**WEST SUSSEX COUNTY COUNCIL  
STRATEGIC PLANNING CONSULTATION**

**SUBJECT: LU/197/15/DOC - Application for approval of matters reserved by conditions imposed under LU/385/14/PL relating to condition No's 3, 8, 10, 11 & 12 - Solar Farm Materials, Landscaping Scheme, Traffic Management plan & SHE Quality plan.**

**Land at Brook Barn Farm, Courtwick Lane, Littlehampton, BN17 7PX**

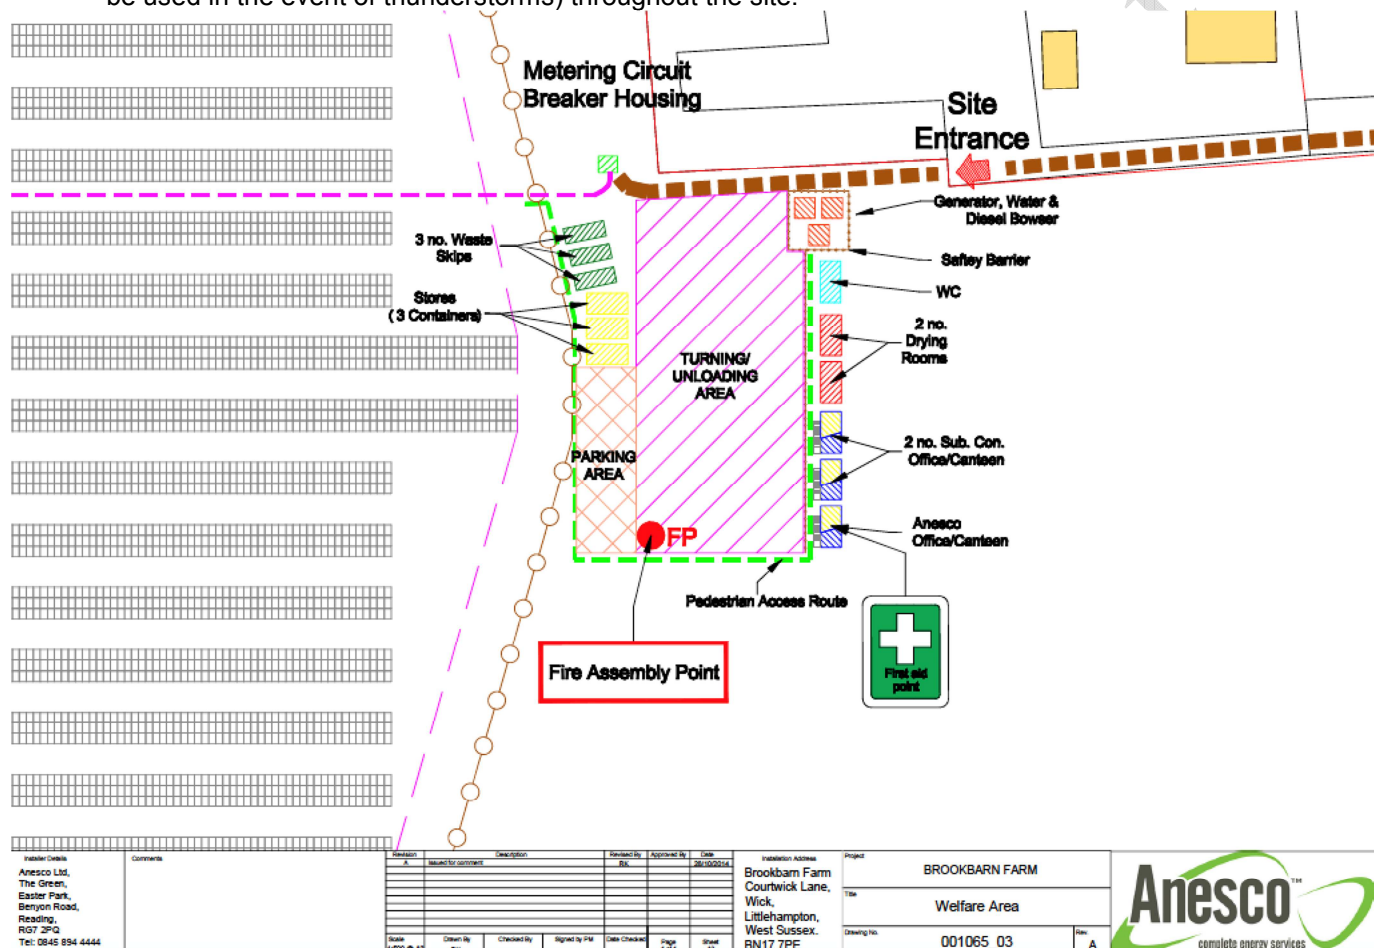
Condition 11: The Applicant has confirmed that there will be no reversing manoeuvres undertaken by HGVs within Old Mead Road. Plan 001453\_03 Welfare Area\_RevC includes an on-site turning area for large vehicles which must be kept clear of other vehicles/equipment at all times.
